WEST SUSSEX COUNTY COUNCIL CONSULTATION

TO:	Arun District Council FAO: A Gardner
FROM:	WSCC - Highways Authority
DATE:	26 August 2020
LOCATION:	Langford, Horsemere Green Lane, Littlehampton, BN17 5QZ
SUBJECT:	CM/27/20/DOC Approval of details reserved by condition imposed under ref CM/64/19/PL relating to Condition Nos 3 - materials & finishes, 4 - Construction Management Plan, 9 - pre-commencement site meeting, 19 - foul drainage and 20 - contamination.
RECOMMENDATION:	More Information

Condition 4 - Construction Management Plan (CMP)

FTA Design HG Right Vehicle (1998)

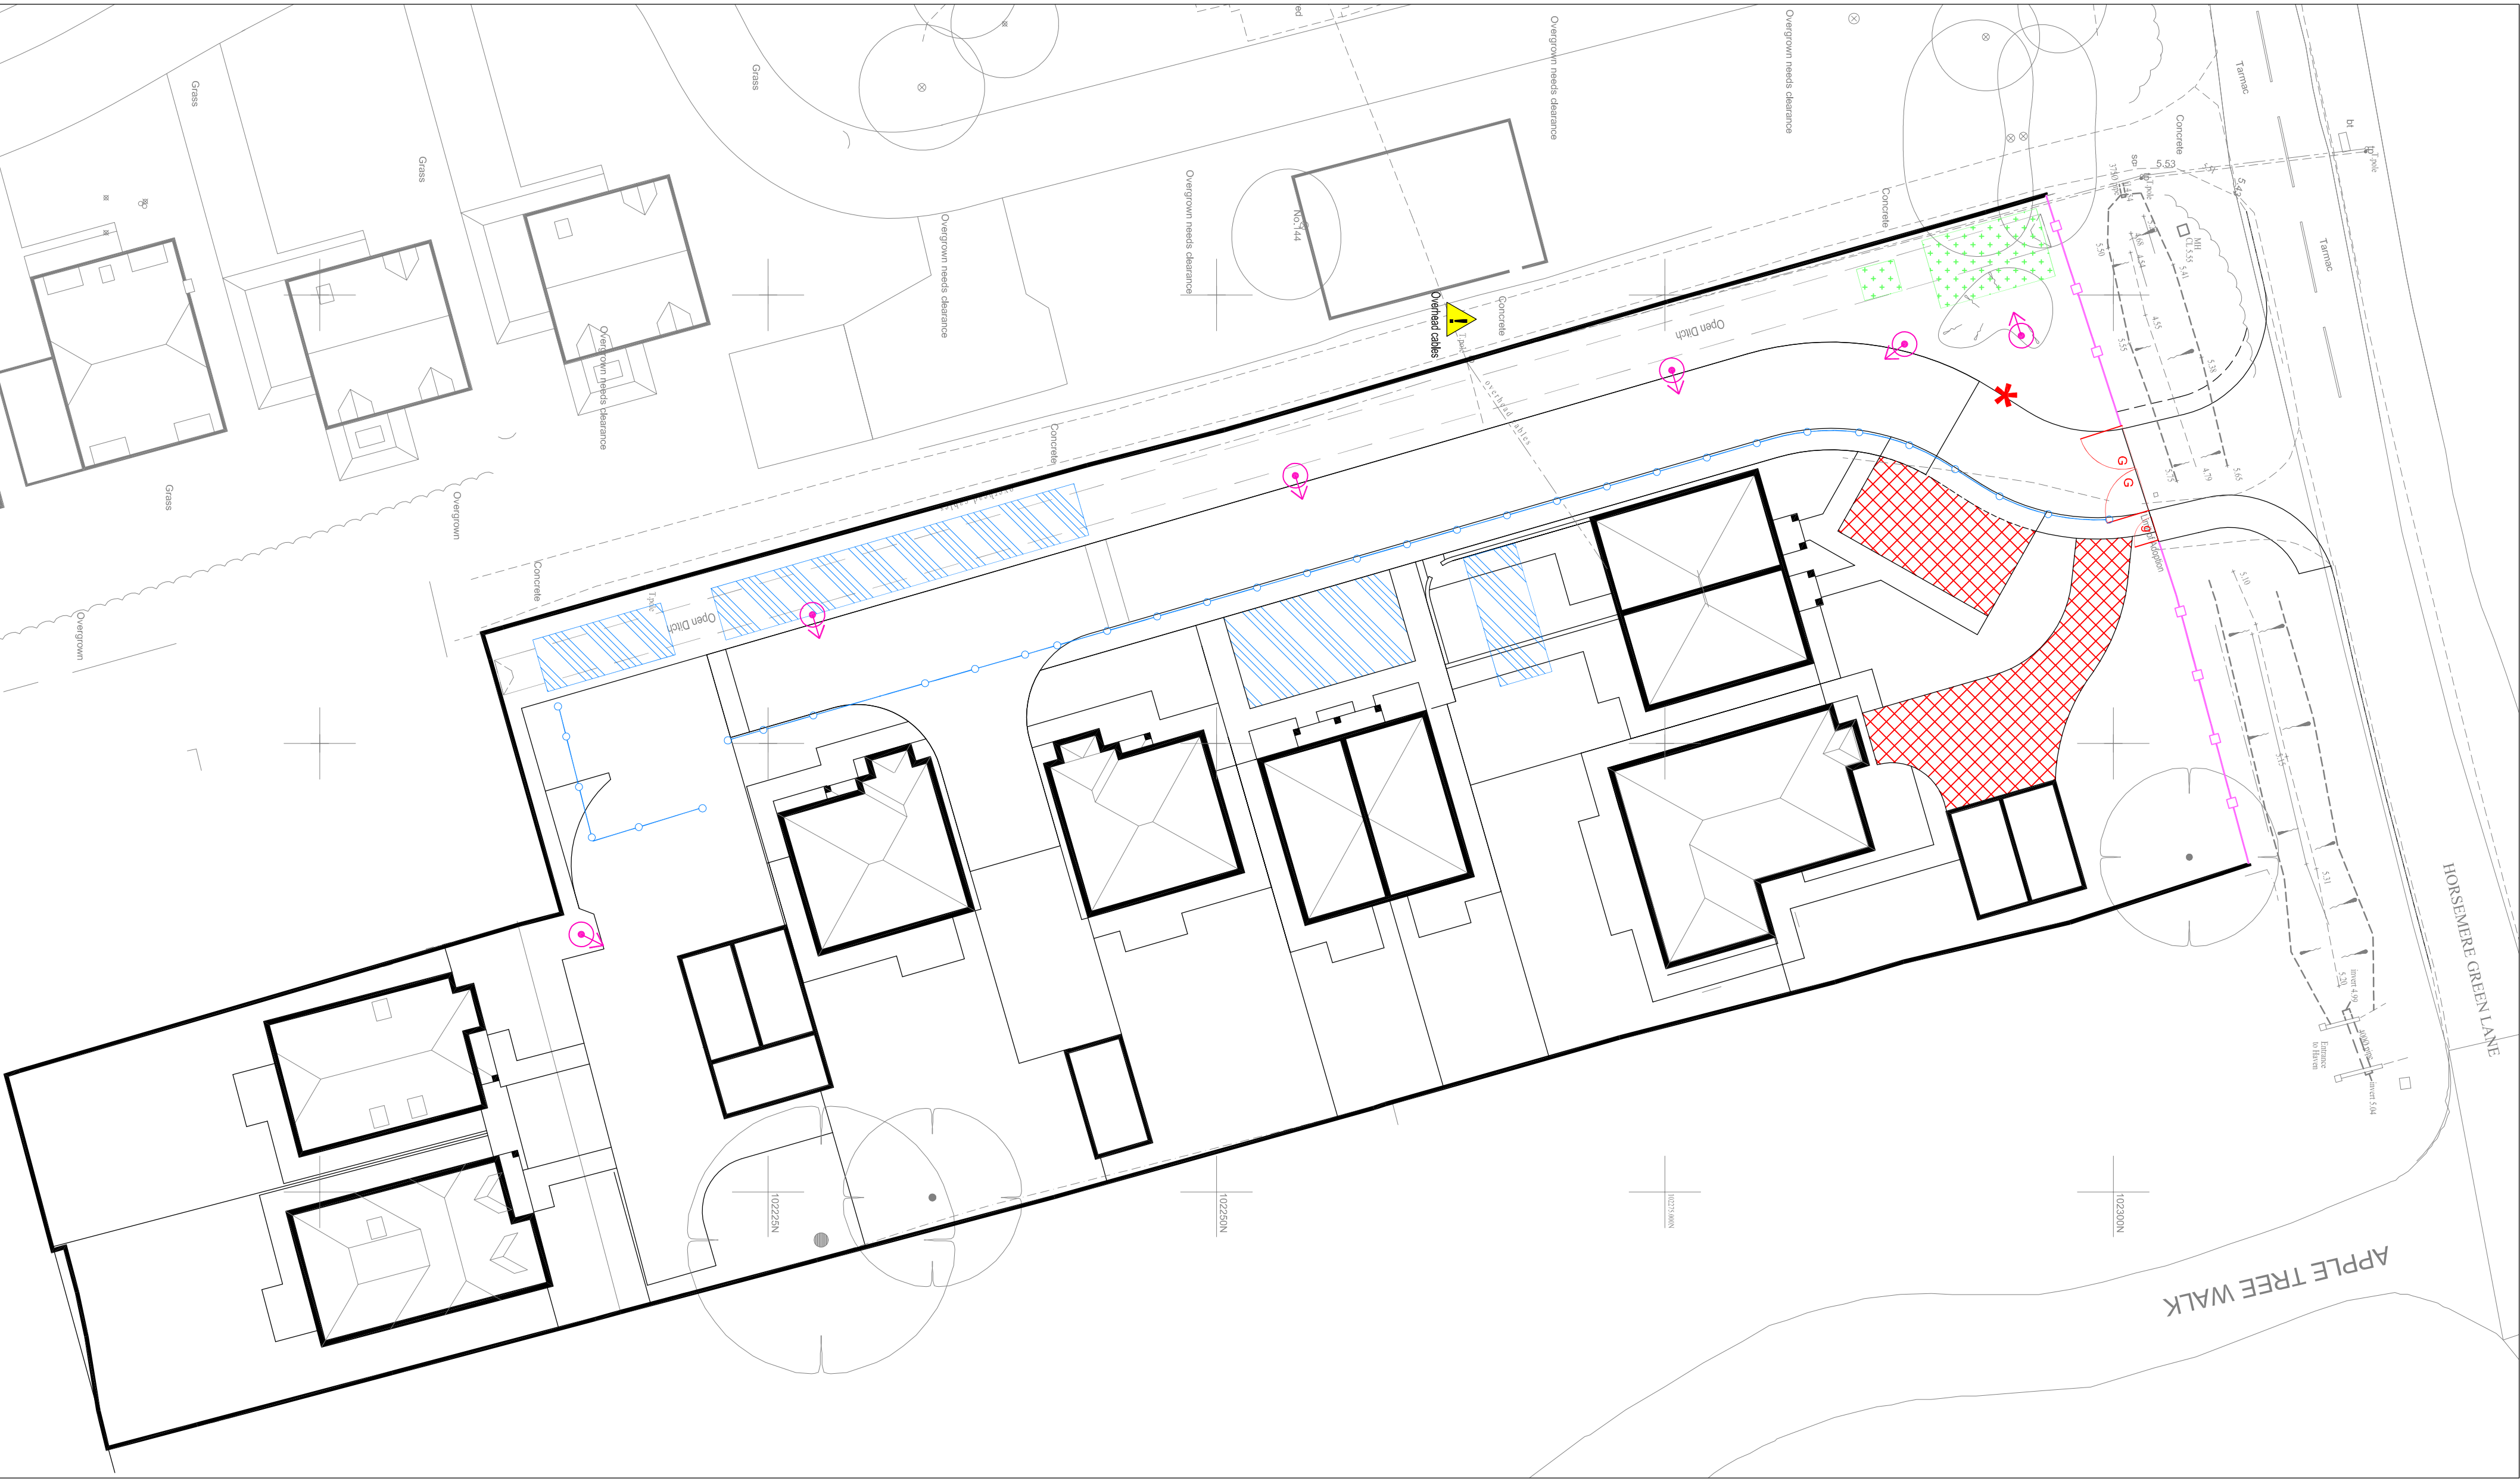
- Large deliveries will reverse in to the site using a banksman. What is the largest vehicle type, number of deliveries and frequency anticipated? Is a temporary vehicle access of suitable width to be provided during construction phase? Swept path tracking plans of the largest construction vehicle would be useful and a turn on site preferential (depending on total vehicle movements to be provided by applicant)
